LATE SCOPING CONSULTATION RESPONSES

Date: 11 April 2017
My ref: PREAPP/17/00145
Your ref: 170309_EN02002
1_000011

PLANNING ACT 2008. INFRASTRUCTURE PLANNING (ENVIRONMENTAL IMPACT ASSESSMENT) REGULATIONS 2009 (AS AMENDED) – REGULATIONS 8 AND 9.
APPLICATION BY SP ENERGY NETWORKS FOR AN ORDER GRANTING DEVELOPMENT CONSENT FOR THE REINFORCEMENT TO NORTH SHROPSHIRE ELECTRICITY DISTRIBUTION NETWORK. SCOPING CONSULTATION

DRAWING TITLE  
SAND AND GRAVEL RESOURCES MAP  
SCC RESOURCE BLOCK OVERLAY  
INSET 1

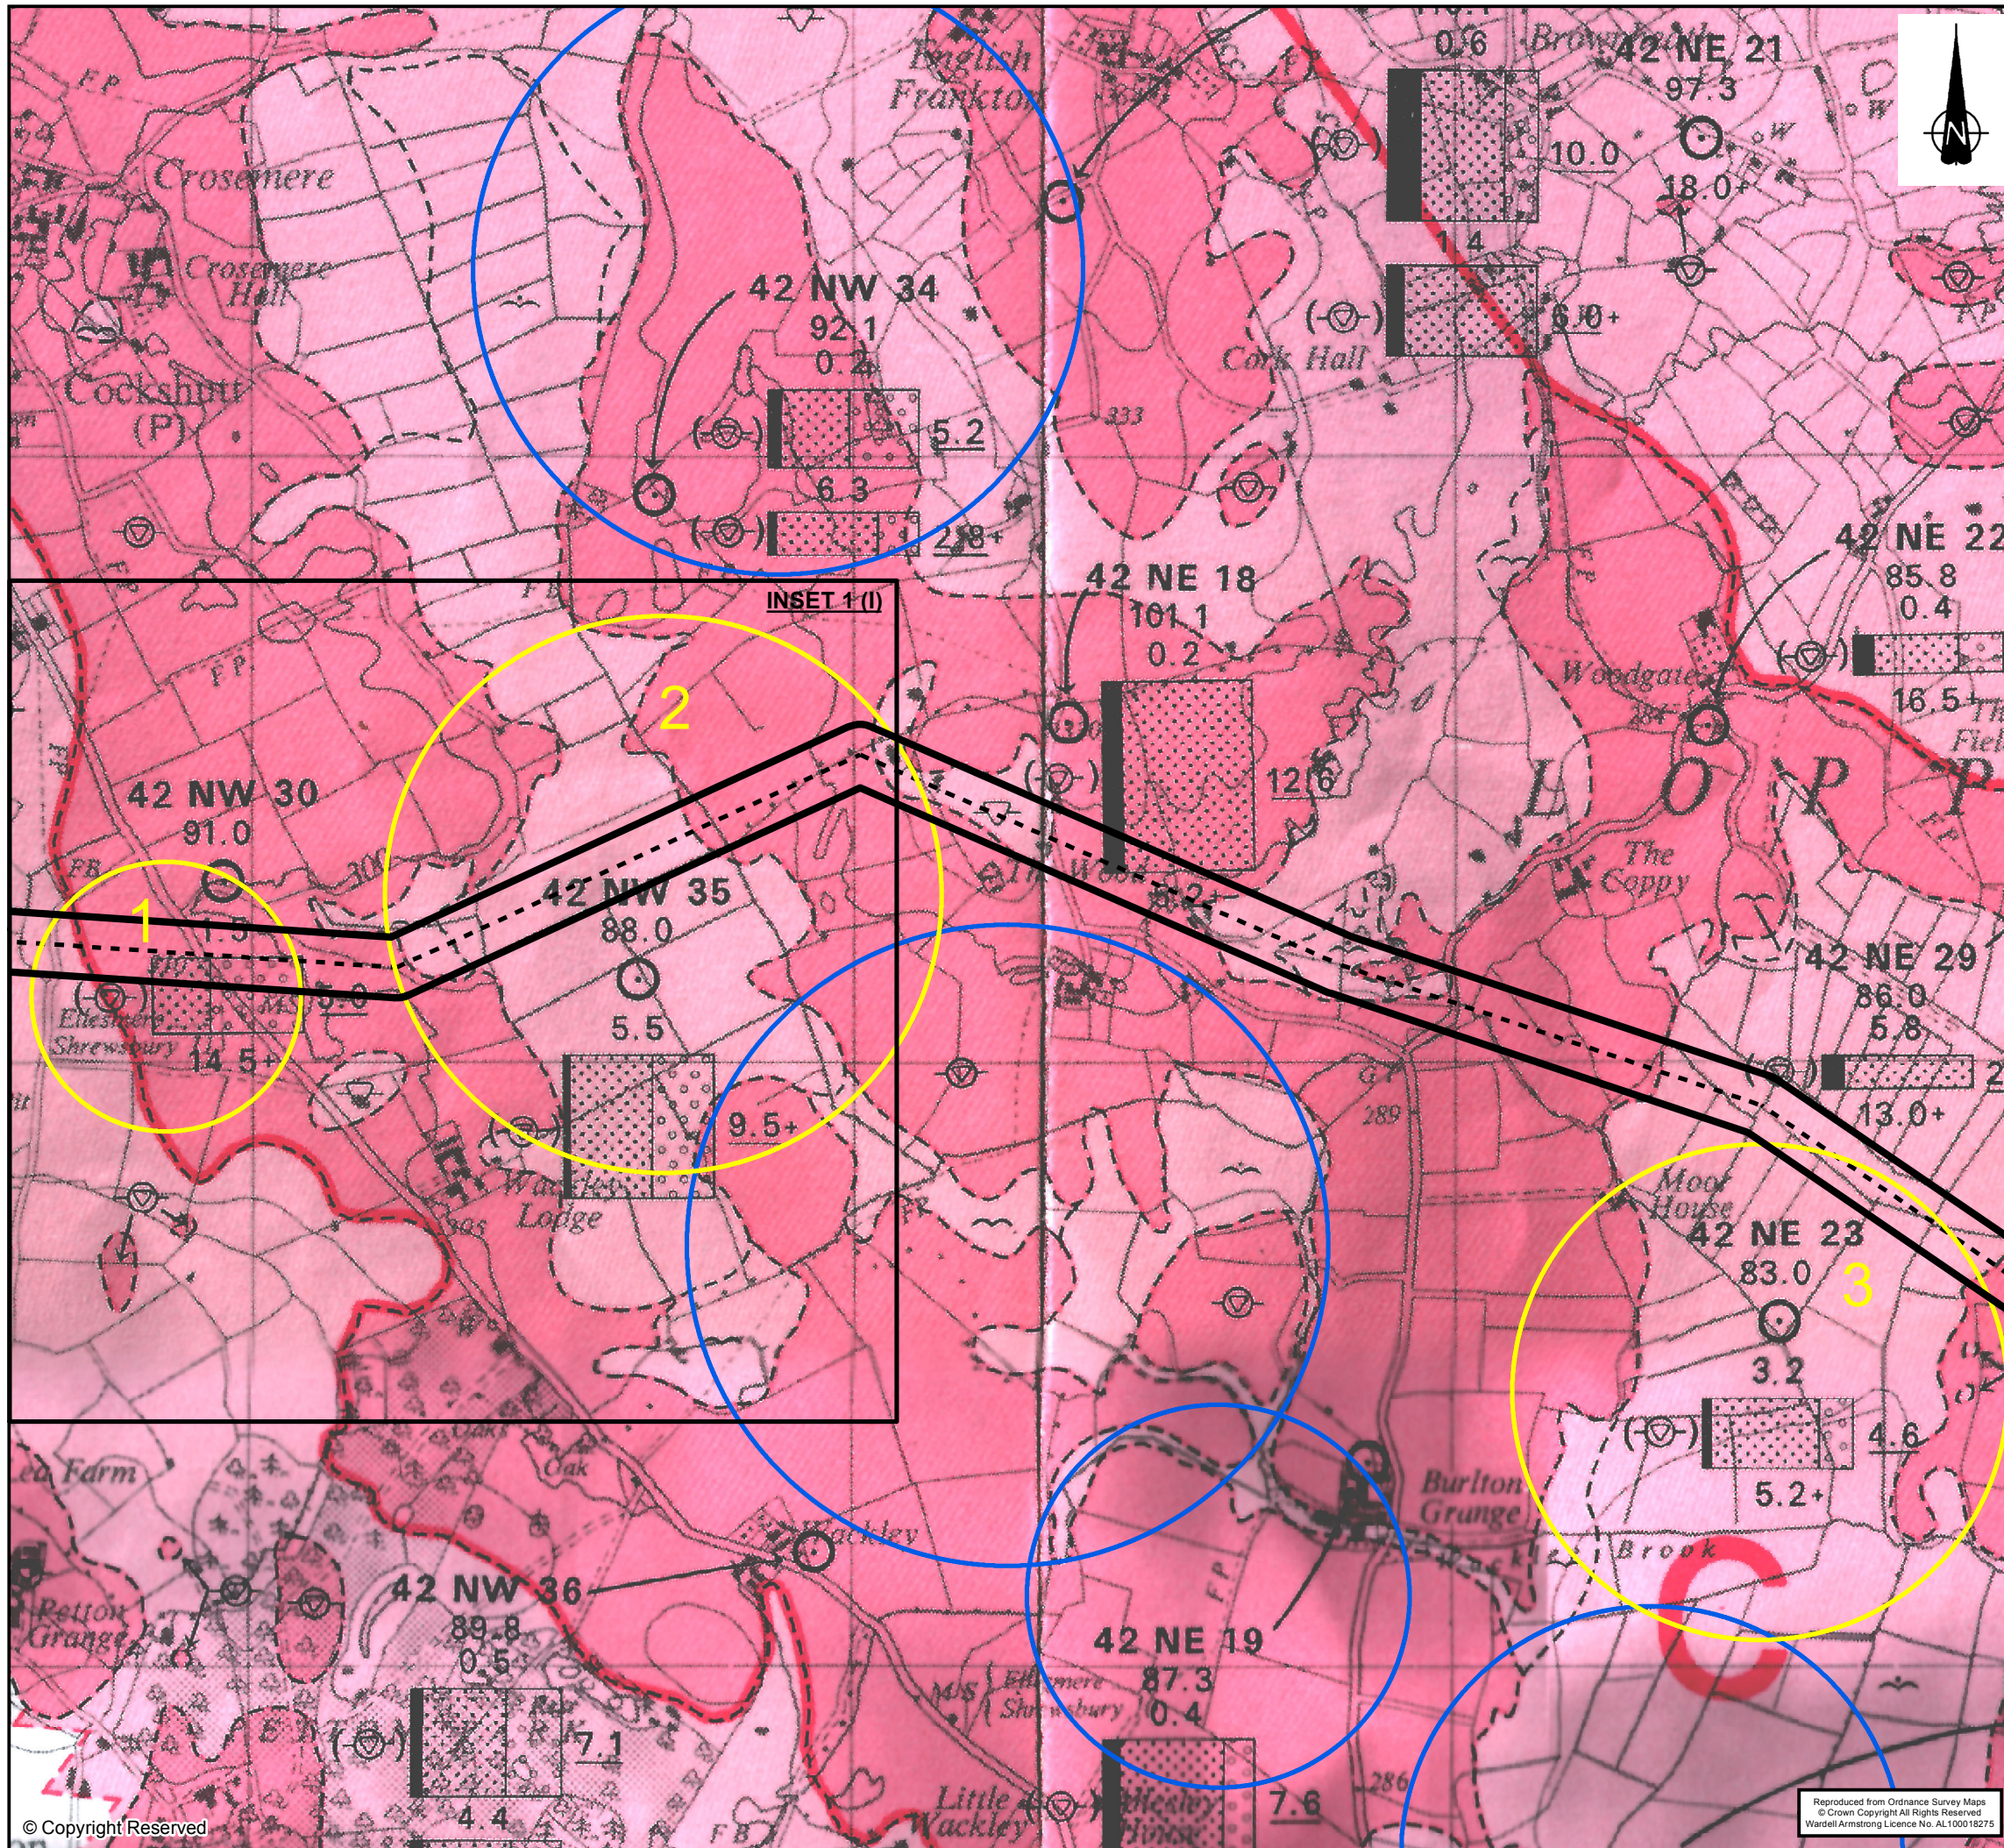
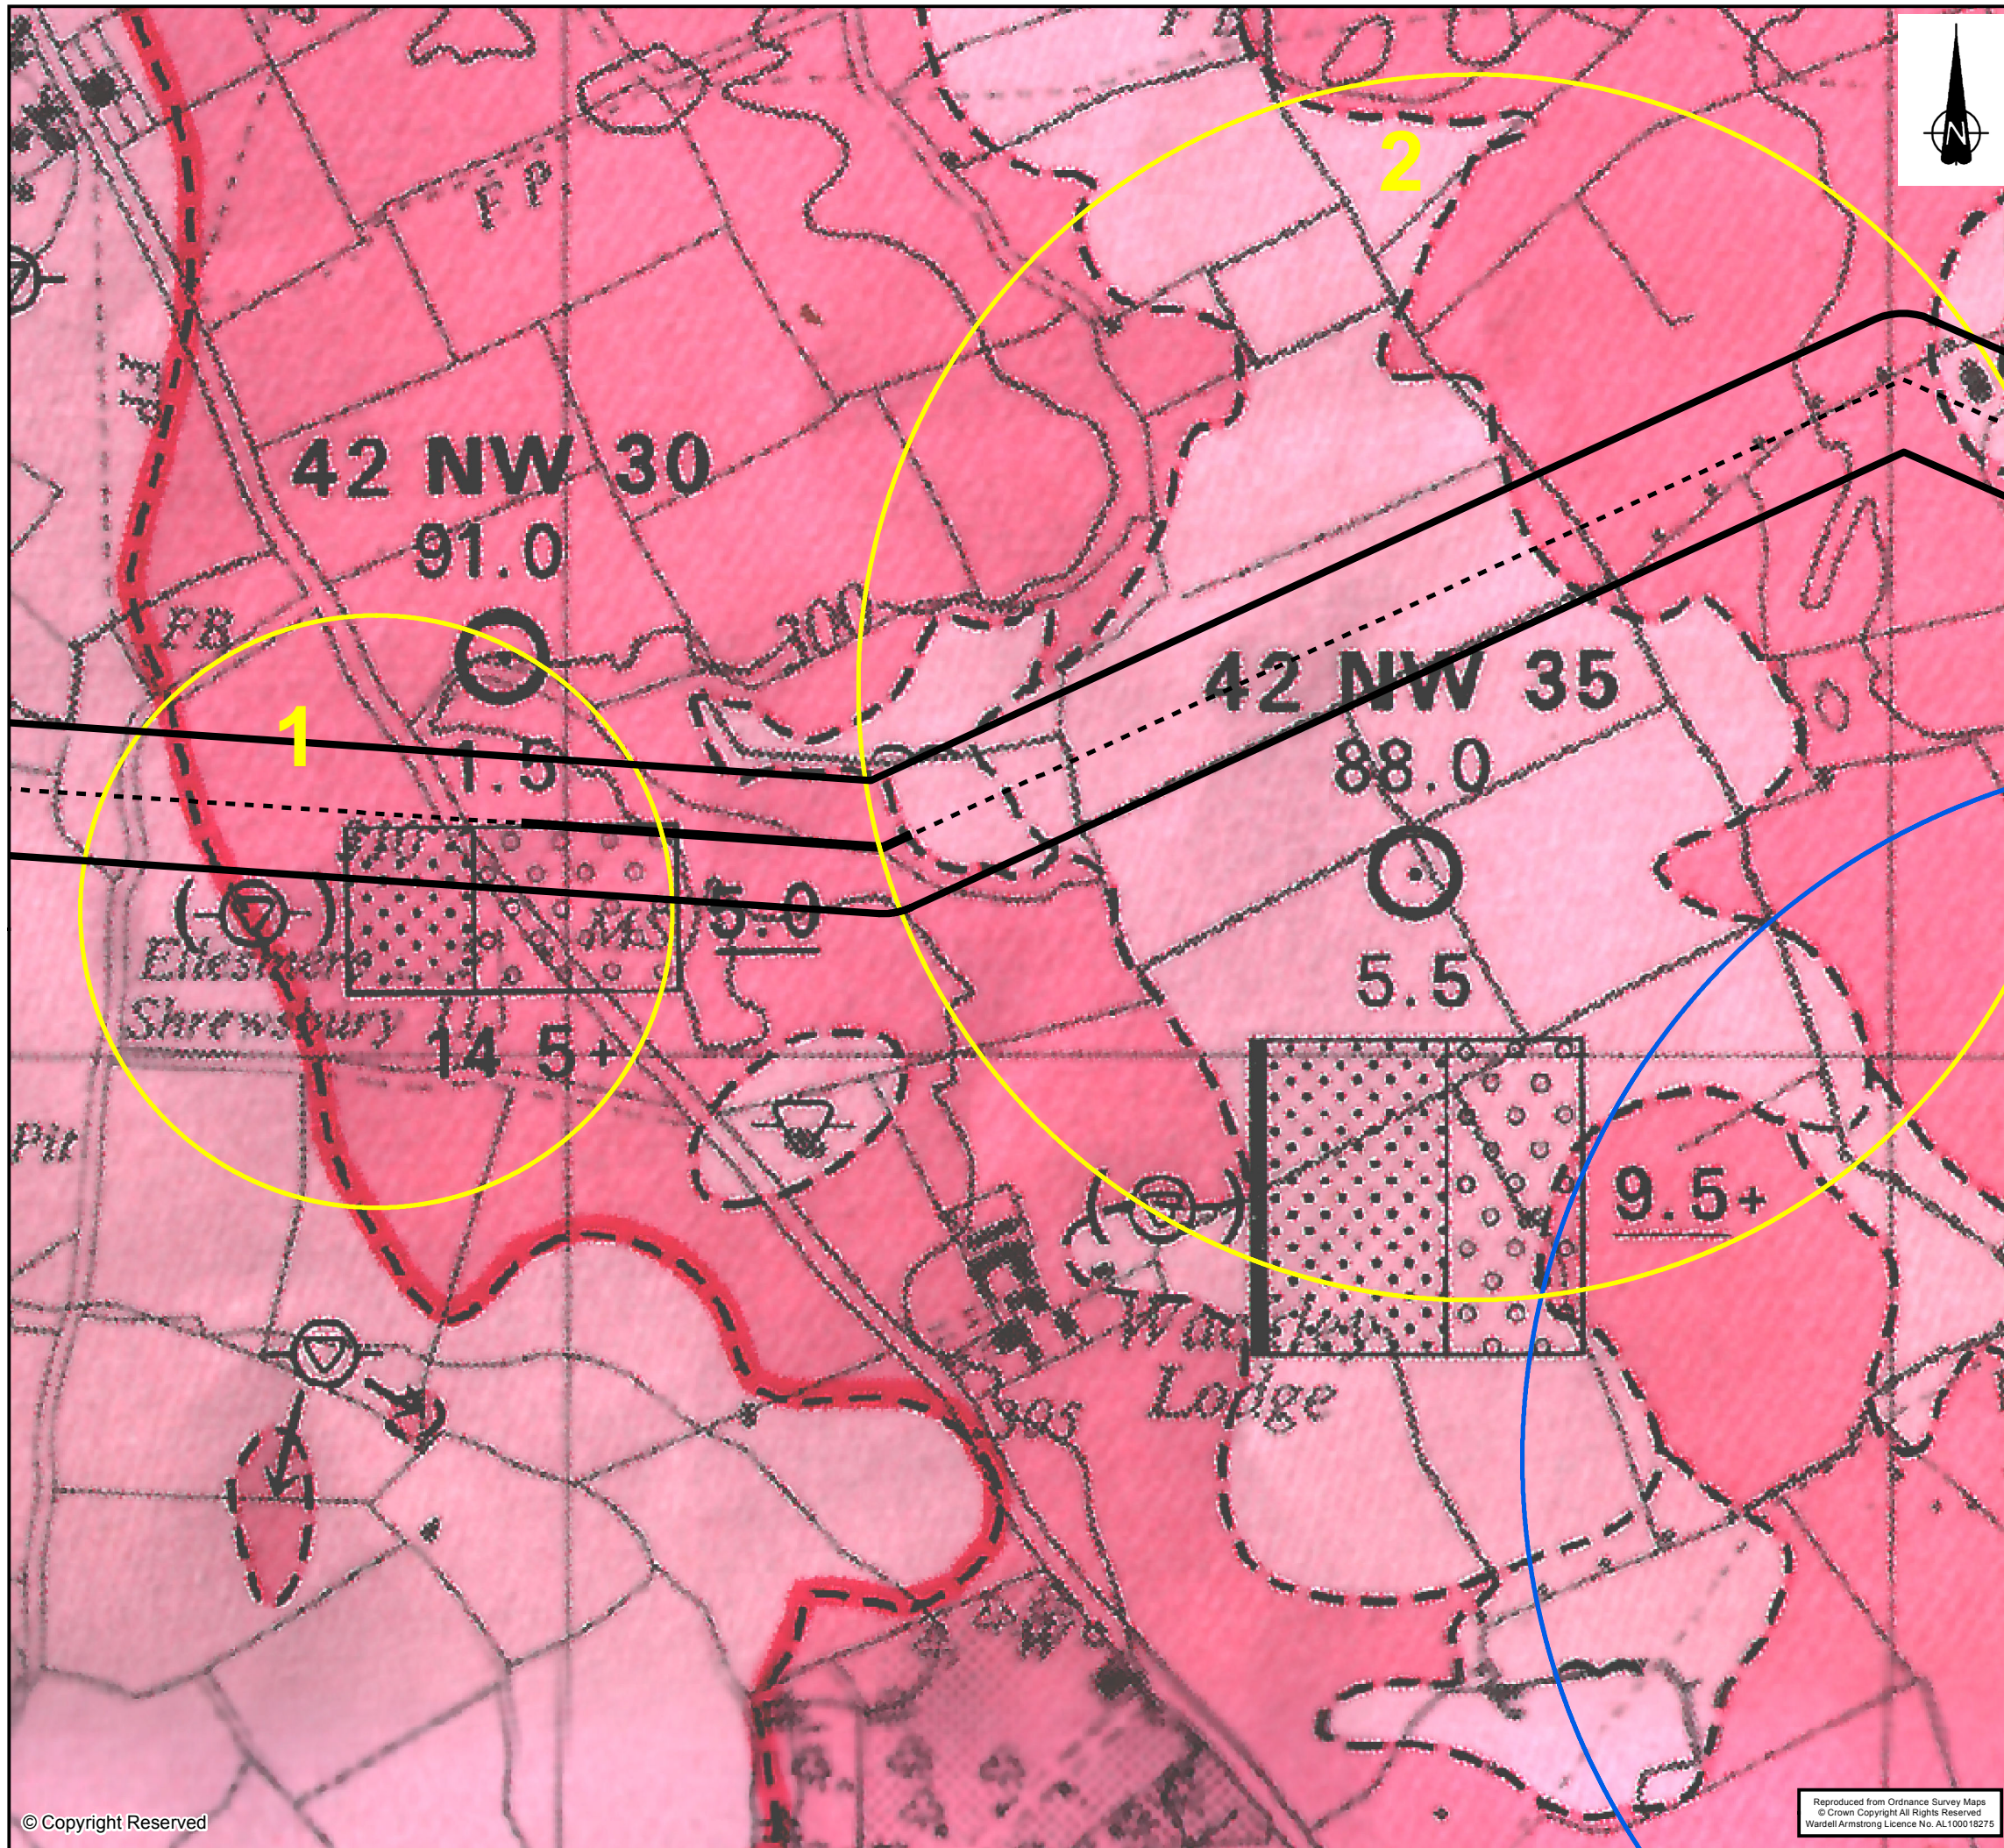
The power line route intersects Mineral Safeguarding Areas (MSA) identified in the Council's SAMDev Plan. SAMDev Policy MD16(3) advises that: 'Applications for permission for non-mineral development in a MSA must include an assessment of the effect of the proposed development on the mineral resource beneath or adjacent to the site of the development or the protected mineral handling facility (termed a Mineral Assessment). This assessment will provide information to accompany the planning application to demonstrate to the satisfaction of the MPA that mineral interests have been adequately considered and that known mineral resources will be prevented, where possible, from being sterilised or unduly restricted by other forms of development occurring on or close to the resource'.

The applicant has commissioned a Mineral Assessment covering the key overlap areas between the power line route and the MSA. This establishes to the satisfaction of the Mineral Planning Authority that there would be no mineral sterilisation issues and hence there is no conflict with policy MD16.

**FIGURE 3.5**  
INDICATIVE  
PHOTOMONTAGE:  
EXISTING AND  
PROPOSED VIEW  
FROM NONELEY

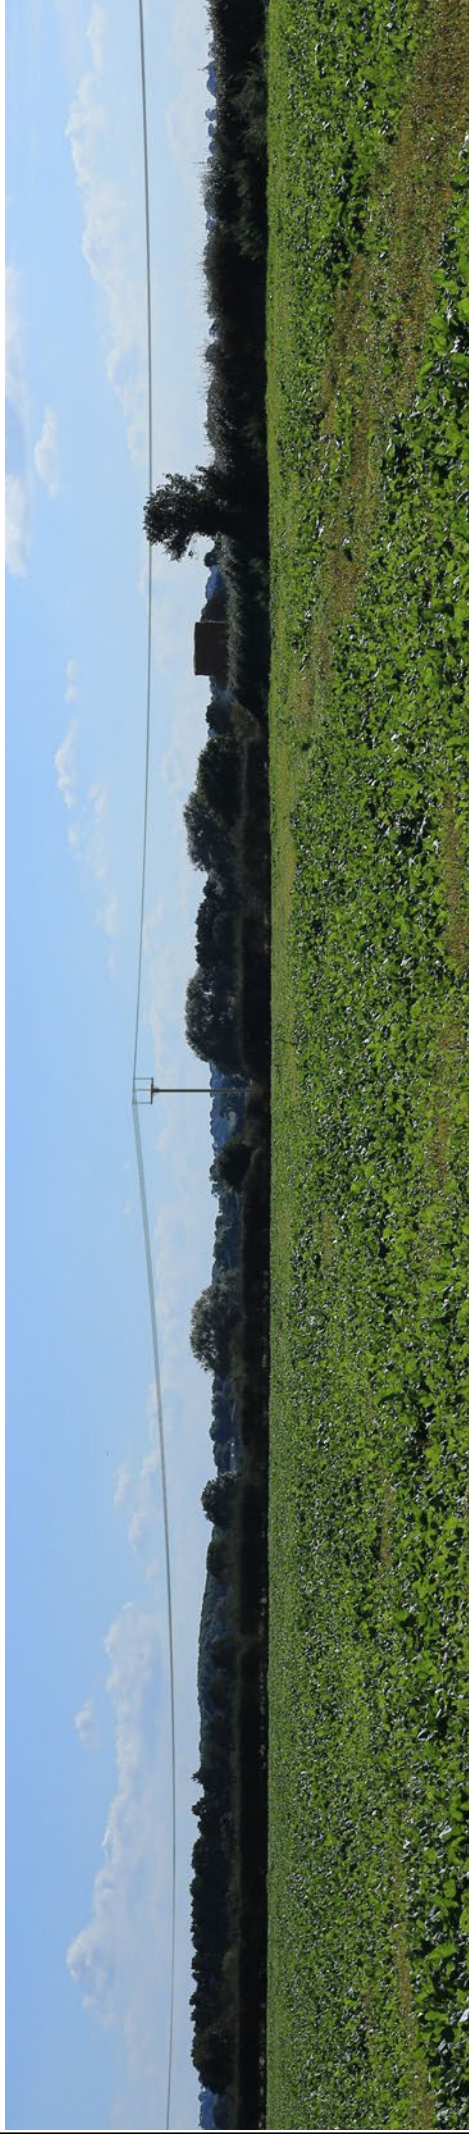
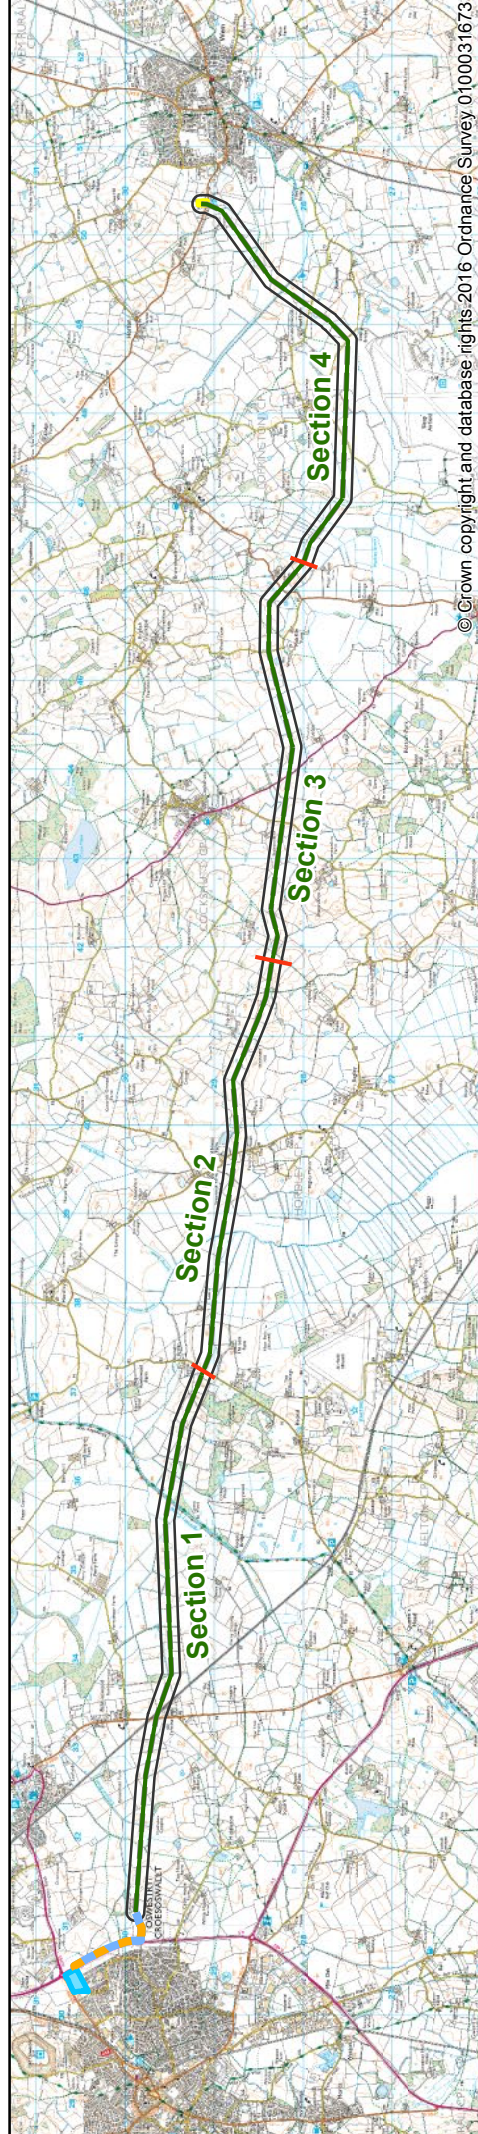
The methodologies are comprehensive, clear, plainly written and appropriate to the latest Guidance. The choice of landscape and visual receptors and the group receptor viewpoints are acceptable. The photomontage from Nonely Hall looks as though it is from a location closer to the line route than expected. It is surprising that the cables are shown as visible above the horizon. This may be more of a concern for the Council's Historic Environment team.
